Recommendation Report for Planning Permission for Works or Extension to a Dwelling

REF NO: M/56/17/HH

LOCATION: 8 Beaconsfield Close
Middleton-On-Sea

PROPOSAL: Demolition of existing flat roof garage & construction of replacement single storey pitch roof side & rear extensions

Title
Elevations as Proposed

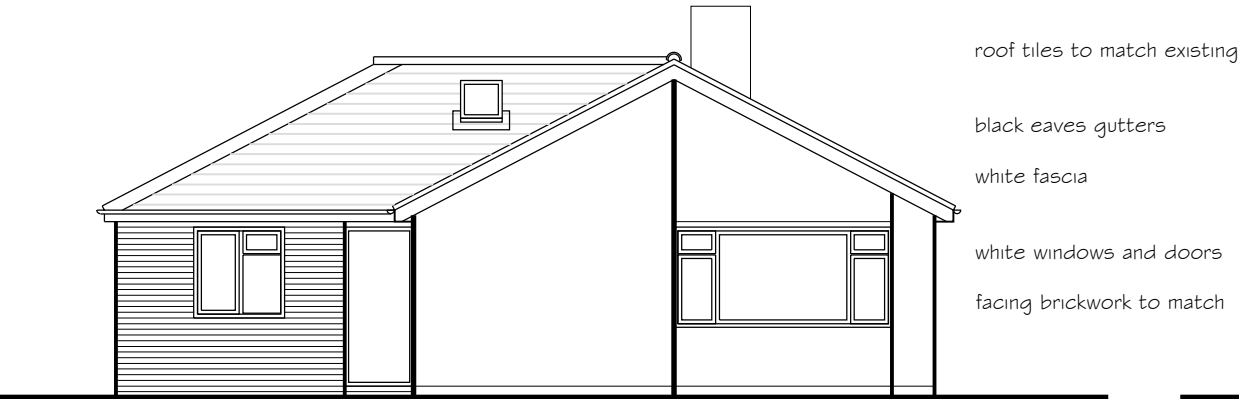
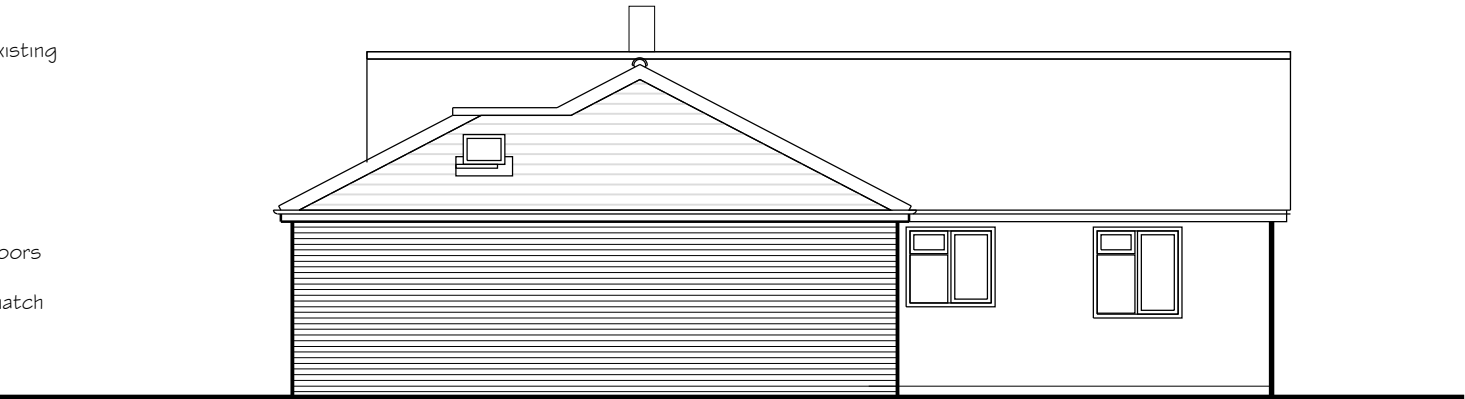
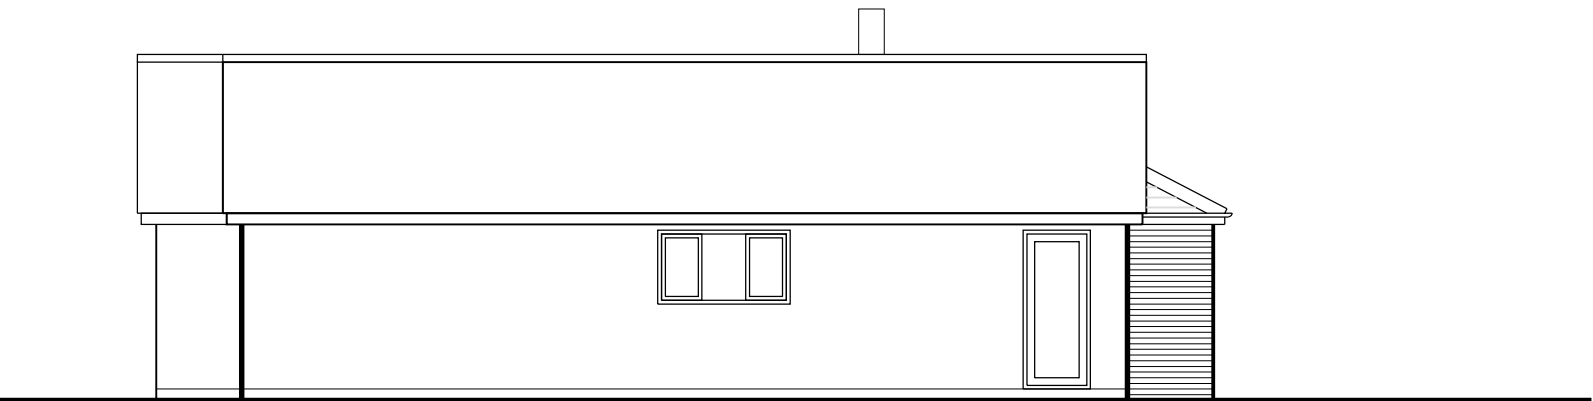
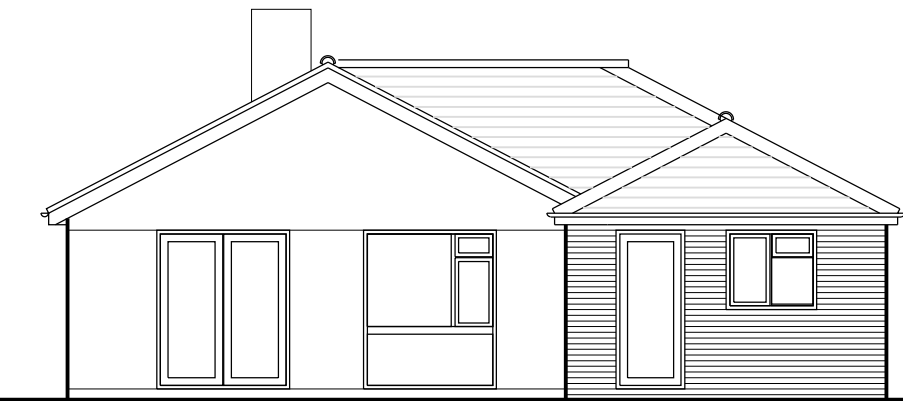
Comments have been received regarding the size of the extension however, this has now been reduced in depth and it is not considered that the proposed extension is unduly large in principle and as such an unduly dominant addition. The change from the single storey garage to provide a hipped roof extension would alter the appearance of the property. However, given the set back of the extension and the height of the extension as a whole it is not considered that the proposed development as a whole would have any adverse harm to the character and appearance of the host property or the wider area.

With regard to the amenity of adjoining occupiers the proposed extension would be built up to the boundary with the property to the north No.10. There are no side windows in the proposed extension and the rear window is at ground floor level therefore there would not be an unacceptable level of overlooking to No.10. Given the existing garage and the height of the proposed extension, albeit the pitched roof increases the overall height, the eaves height is comparable to the height of the existing garage. Therefore, it is not considered that the proposed, amended, extension would be harmful to the amenity of adjoining occupiers at No.10.
